Request for Information 1, 7833 SE 28th St--revised
Project #DSR20-010 & SEP20-005

Per the comment letter dated October 20, 2021, below is the response to this comment letter along with the revised and updated plan set.

SITE PLAN

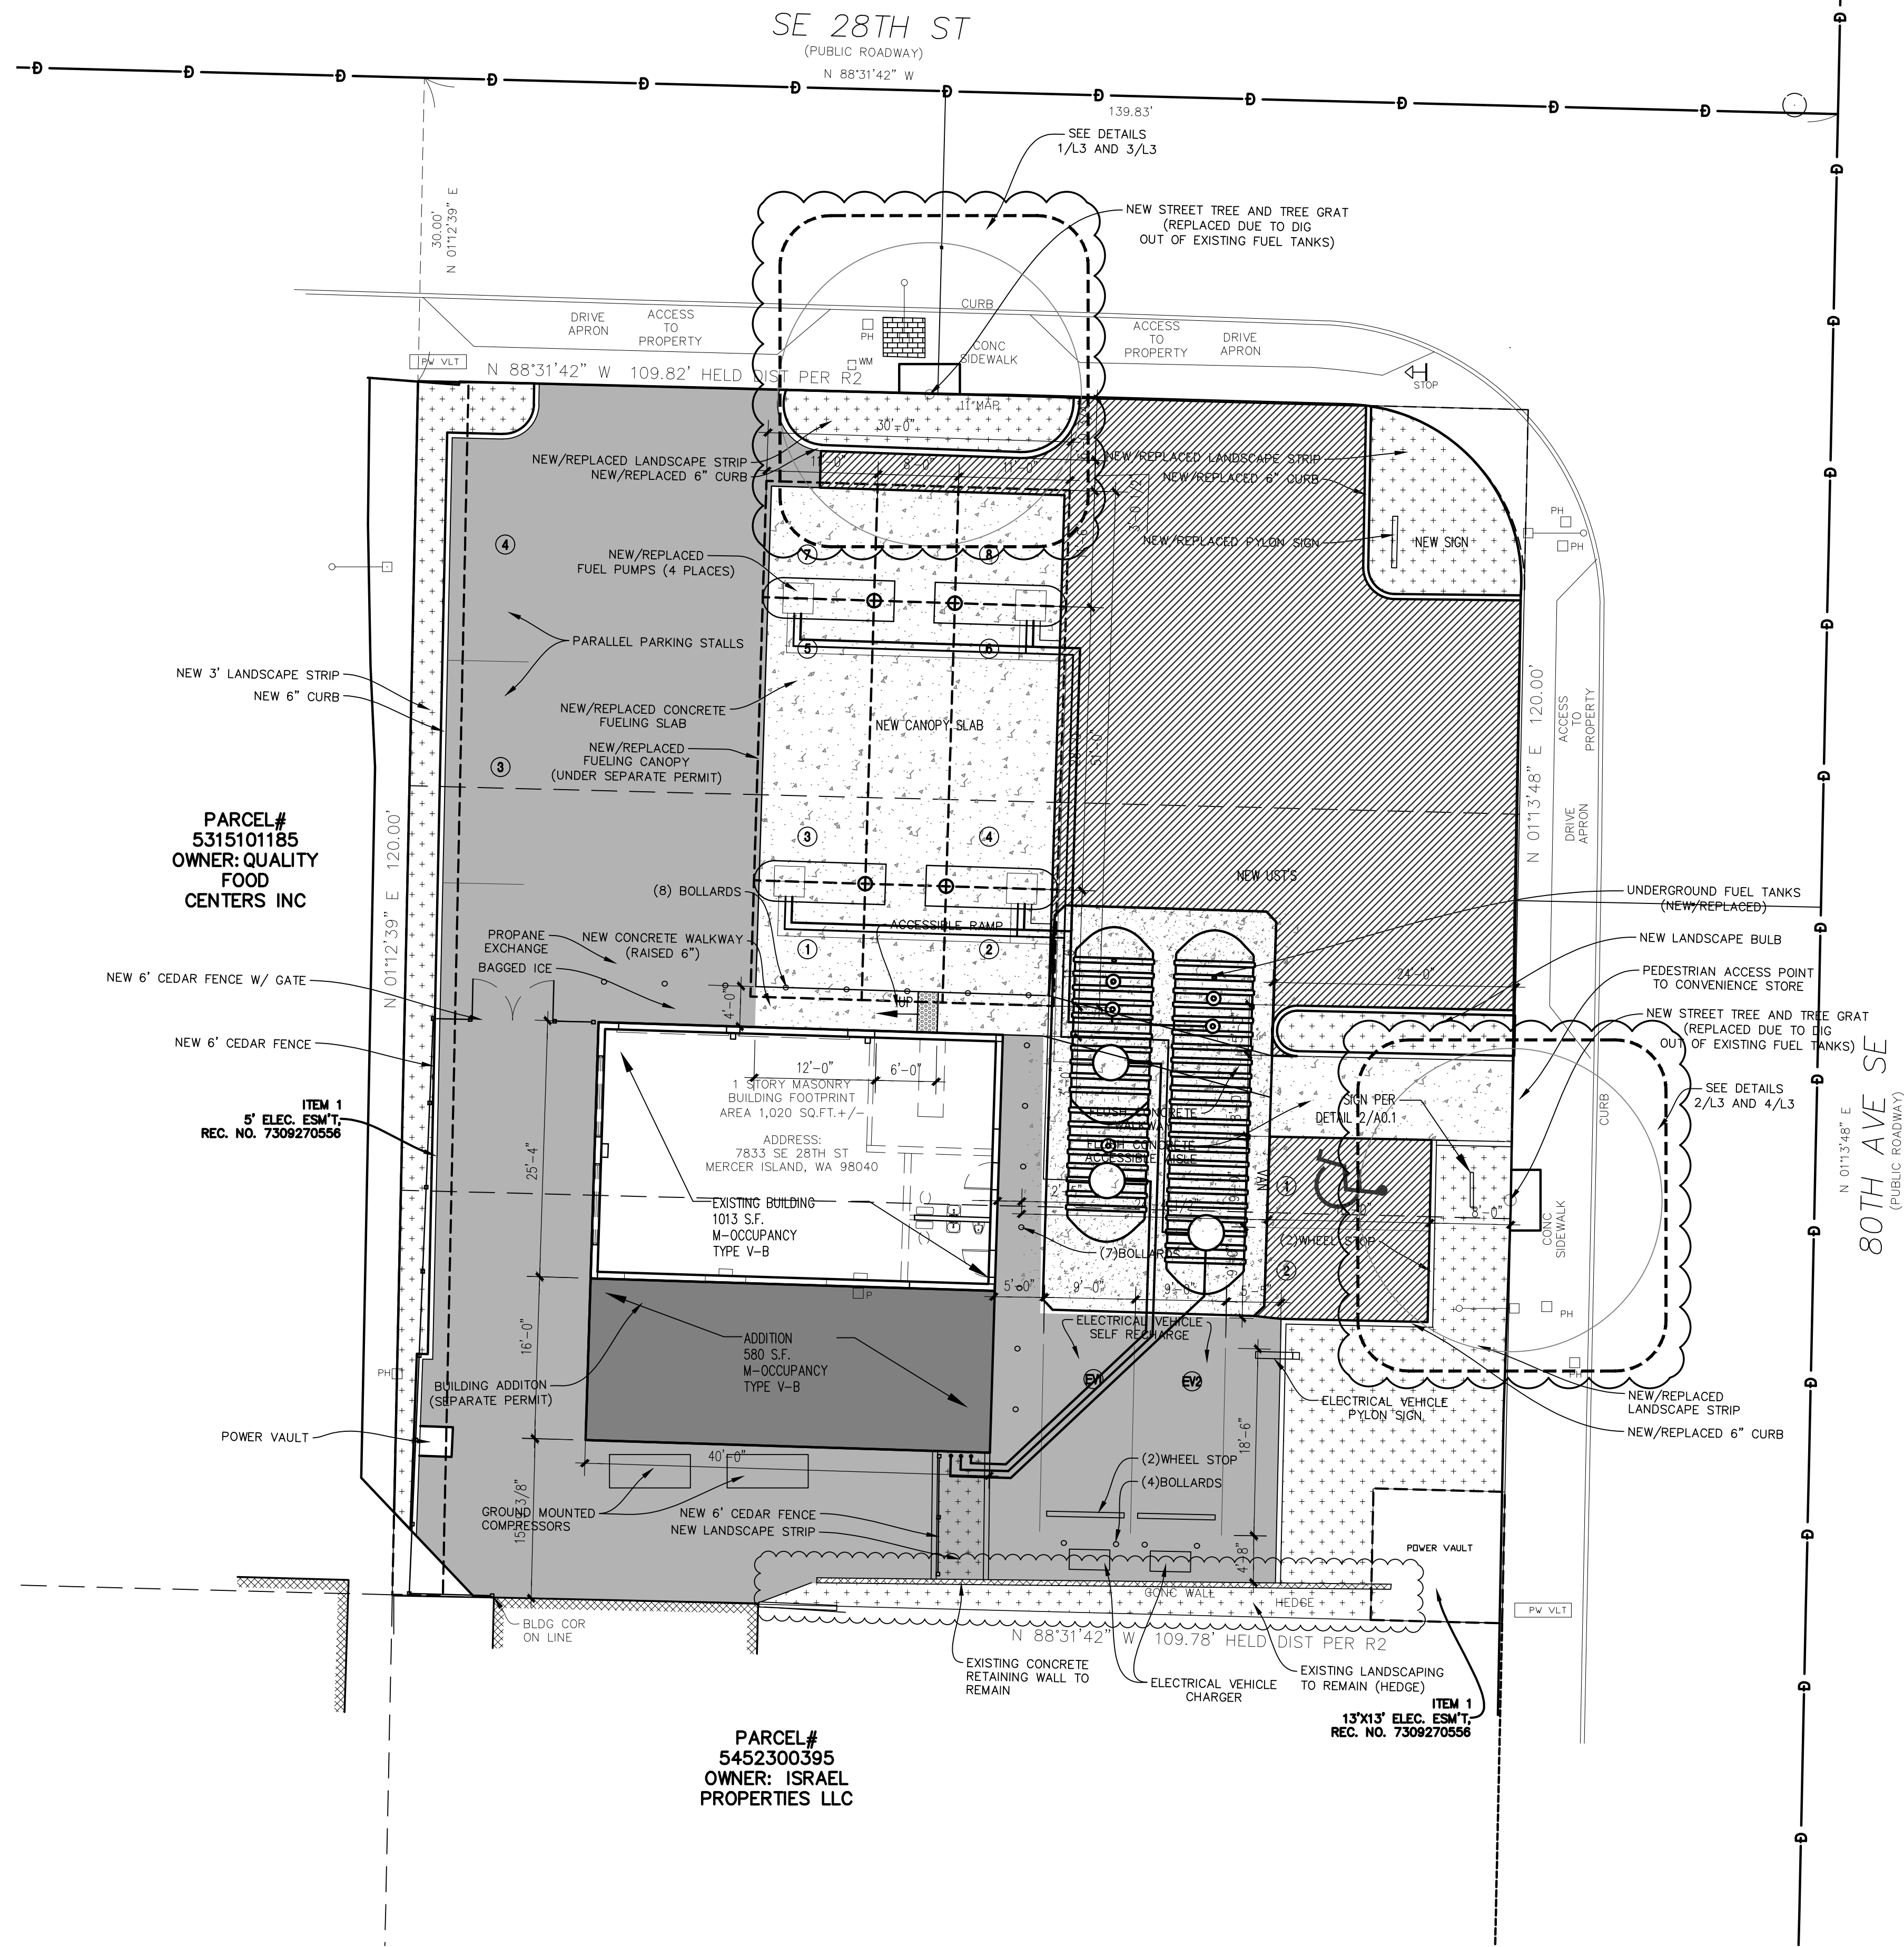
1. Illustrate on the site plan what is existing, to be removed, and proposed. Is any new concrete proposed? Will any of the asphalt be replaced?

RE: Please see demo site plan sheet A0.2 and site plan sheet A0.1

**TREE PROTECTION (EXISTING CONDITIONS)**

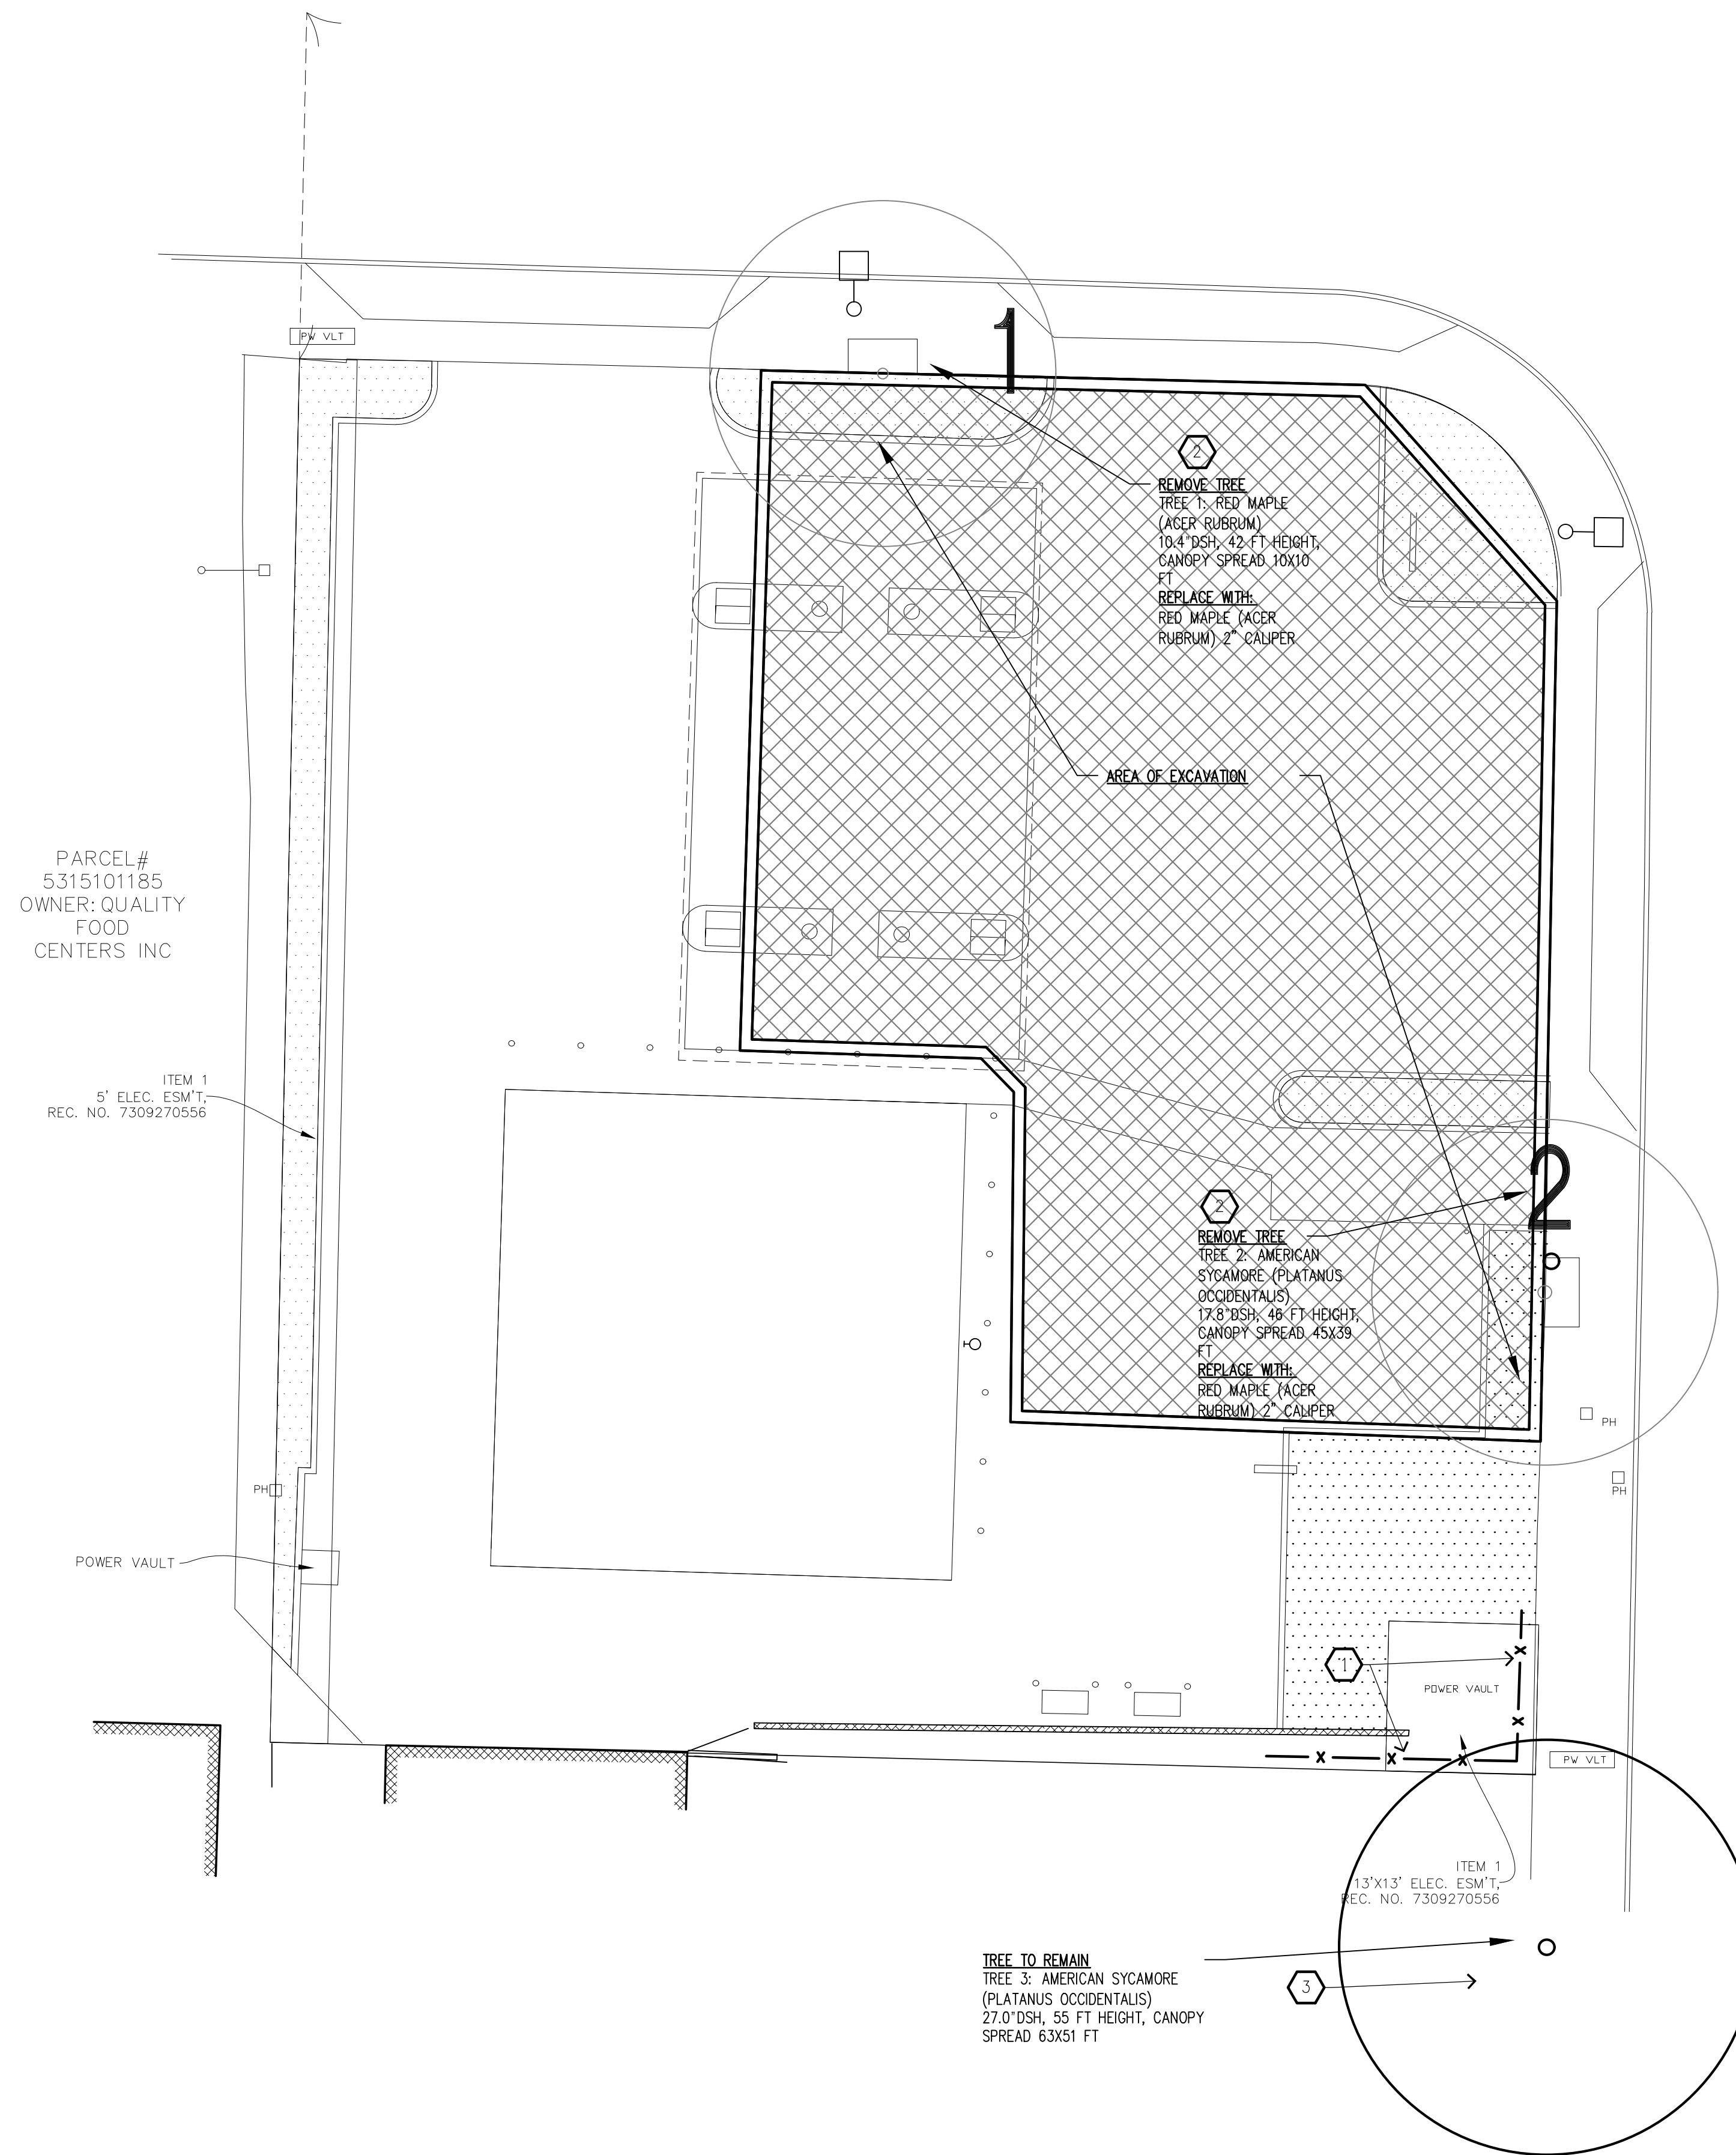
1. Show trees on plans with limits of expected excavation.

2. Tree protection of all trees within work area.

3. A contingency plan in the event the city trees need to be removed to mitigate contaminated soil. This would include posting the trees with estimated time of work and possibility of trees removal and replacement. A Qualified Arborist will also be required for excavation within trees dripline. Tree replacement if required will be directed by the city. You will be responsible for the cost of replacement and watering for three years.

RE: All trees will be removed please see plan sheet TP-1 and L-1.0

RE: Please see sheet TP-1

RE: As noted on plans all existing trees will be removed, please see TP-1, L1.0 and L2.0, also arborist report.
